A46 Newark Bypass – Development Consent Order Application

A46 from Farndon Roundabout to Winthorpe Roundabout, near Newark-On-Trent

Deadline 2 – The Examining Authority’s written questions and requests for information (ExQ1)

Appendix 1 – Environment Agency responses to ExQ1

Figure 10: Slough Dyke realignment – extract from AS-007 (General Arrangement Plans) Sheet 25005

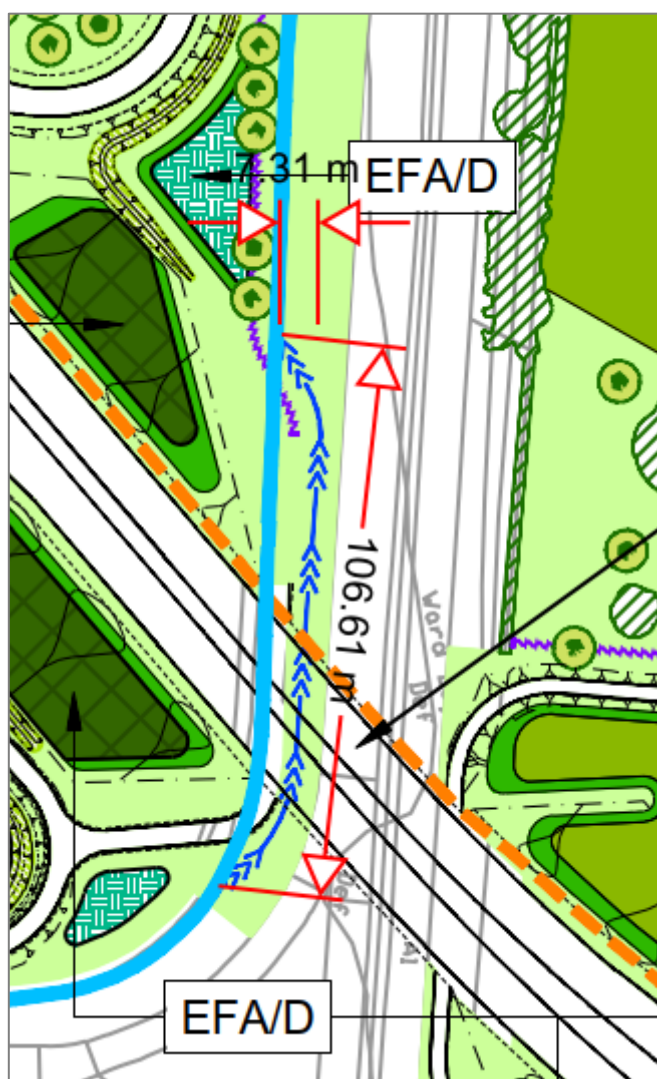
<p>Q15.1.12</p>	<p>The Applicant</p>	<p>Slough Dyke (main river) Realignment No detailed drawings for the Slough Dyke realignment have been provided and the realignment has also not been represented within the hydraulic modelling undertaken.</p> <p>Detailed drawings should be provided and with-mitigation scheme modelling re-run with the realignment to understand the flood risk impacts</p>	<p>Within the most recent Hydraulic Modelling Technical Note (Document ref. HE551478-SKAG-EGN-CONWI_CONW-RP-CD-00002, Revision P01, dated 22 October 2024), as submitted to us for review outside the Examination process, the Applicant has shown that the realignment of Slough Dyke has now been tested within the hydraulic model and confirms no impact on flood risk. No further action is required by the Applicant with regards to testing the Slough Dyke re-alignment within the hydraulic model. The Hydraulic Modelling Technical Note should be included as</p>

<p>appendix of an updated FRA to be submitted as part of the DCO application.</p> <p>While the Applicant has provided sufficient evidence to us to demonstrate that the realignment of Slough Dyke will not have an adverse impact of flood risk, we are still awaiting detailed plans of the proposed river channel in situ. The Environment Agency requires satisfactory cross-sectional plans of the channel and drawings of the channel connecting to the existing channel in order to full resolved this issue.</p> <p>Once a satisfactory revised FRA and plans as mentioned above have been submitted as part of the DCO application, we will be able to resolve this issue.</p>
<p>Q15.1.13</p>	<p>The Applicant</p>	<p>Climate change Allowances Sensitivity Test The FRA has not assessed a credible maximum peak river flow climate change scenario, in line with UK government guidance on climate change allowances for flood risk assessments.</p> <p>The Applicant should review the EA’s RR [RR-020] and provide a detailed comment that should include a sensitivity assessment of the Upper End (62%) climate change allowance for peak river flow.</p>	<p>Within the most recent Hydraulic Modelling Technical Note (Document ref. HE551478-SKAG-EGN-CONWI_CONW-RP-CD-00002, Revision P01, dated 22 October 2024), as submitted to us for review outside the Examination process, the Applicant has provided evidence that the necessary sensitivity testing has been undertaken to accurately assess the impact of climate change to the scheme.</p> <p>In particular, the Hydraulic Modelling Technical Note satisfactorily demonstrates the impacts of a credible maximum scenario on the development. No further action is required by the Applicant with regards to testing a credible maximum scenario.</p>
